Title
PROPOSED GROUND FLOOR PLAN

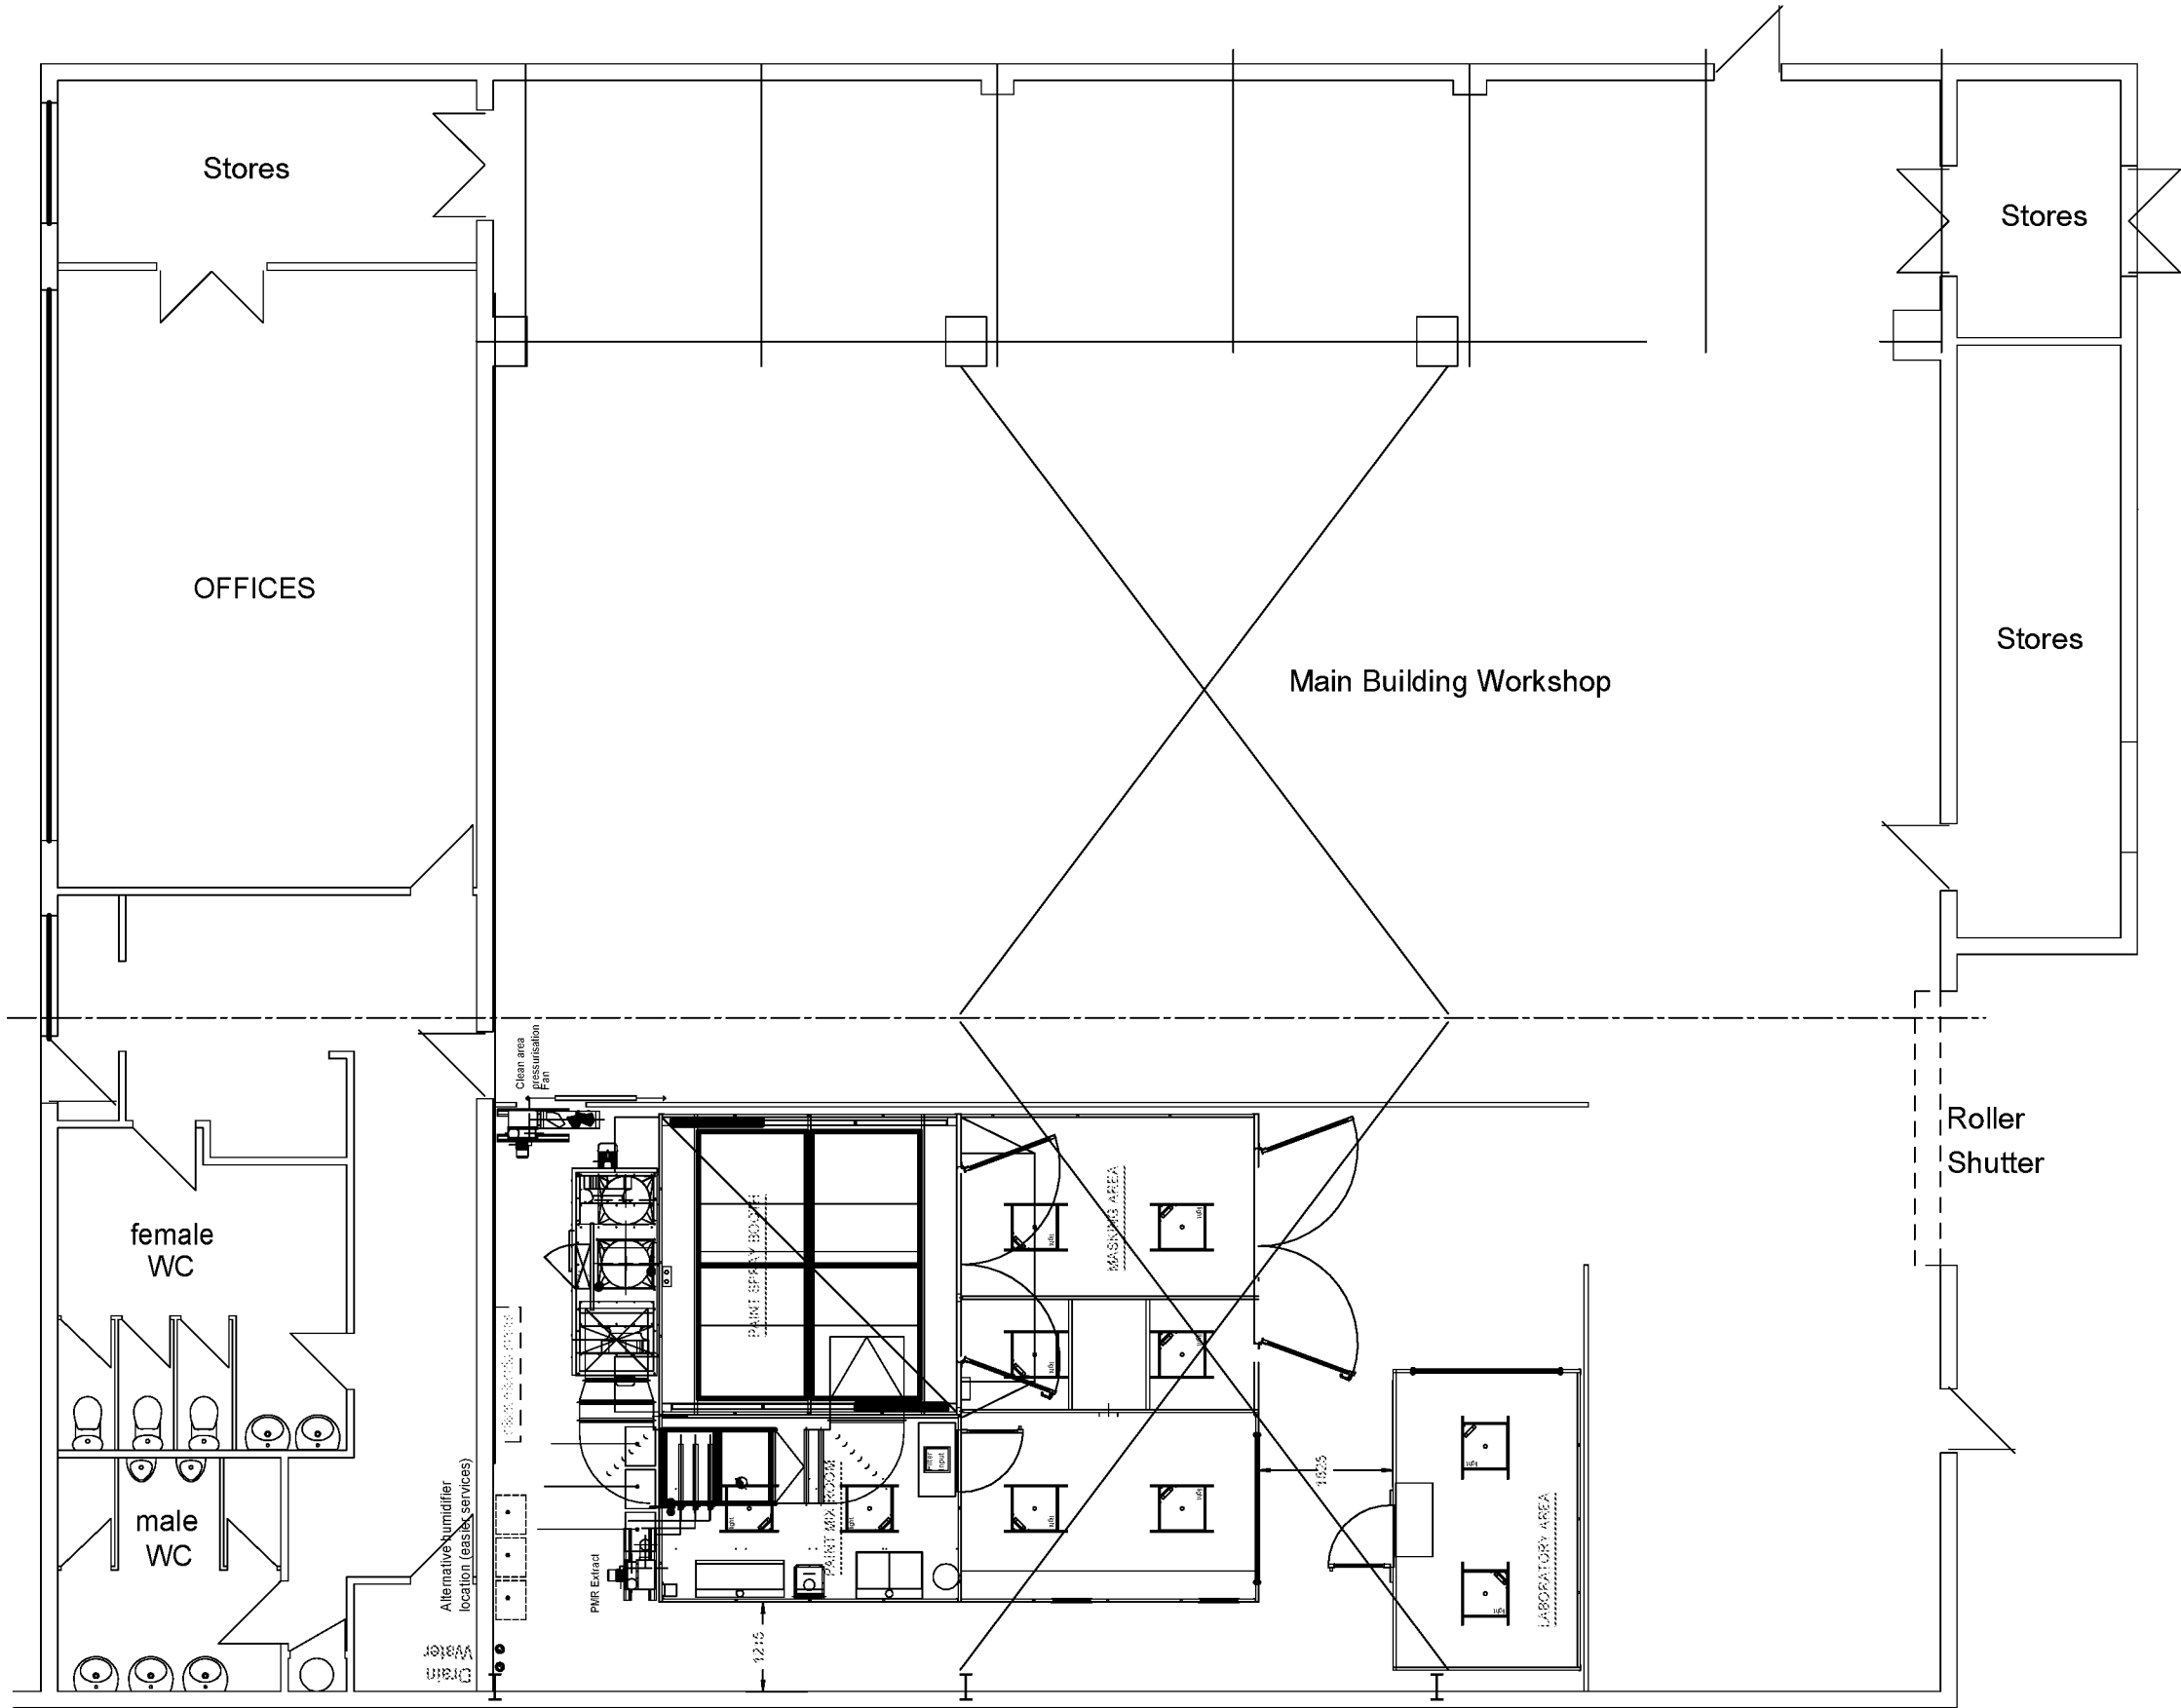
- The use of paint spray booths may require a permit under the Environmental Permitting Regulations 2016 depending on the type and quantity of paints or products to be used. If a permit is required this may dictate the stack heights in order to allow for adequate dispersion. In order to ensure that the stack heights applied for will be suitable should a permit be required, more information should be provided on the type and quantity of paints that are proposed to be used in the spray booth and what materials and products they are being applied to. The applicant may wish to review the process guidance note relevant to their business for further information on permit requirements (most likely under the solvents section) and the relevant note should be referred to in the extra information submitted. Local Air Pollution Prevention and Control (LAPPC): process guidance notes - [GOV.UK \(www.gov.uk\)](https://www.gov.uk)

It is possible that a full noise assessment may be required given the existence of residential properties on Ash Grove. An important factor in determining whether this is required is the proposed operating hours. The applicant should therefore provide information on the proposed operating hours of the spray booth. If it is to operate at night this has more potential for noise disturbance.

Sorry for the delay in responding to this request it appears to have just been overlooked, my apologies, I can confirm the materials which will be applied within the new paint booth will be as follows: -

Indestructible Paints IP9183-R1 High Heat resistance sacrificial aluminium coating.

Indestructible Paints IP9184-R1 Ipseal High Heat Temperature Inorganic Seal.

Indestructible Paints 985 Series Rockhard stove enamel paint.

We would estimate with the product knowledge gained a total usage in weight of 100kg in total across all products, the components we intend to paint are various components from industrial gas turbine engines and manufactured from Aluminum and nickel based alloys.
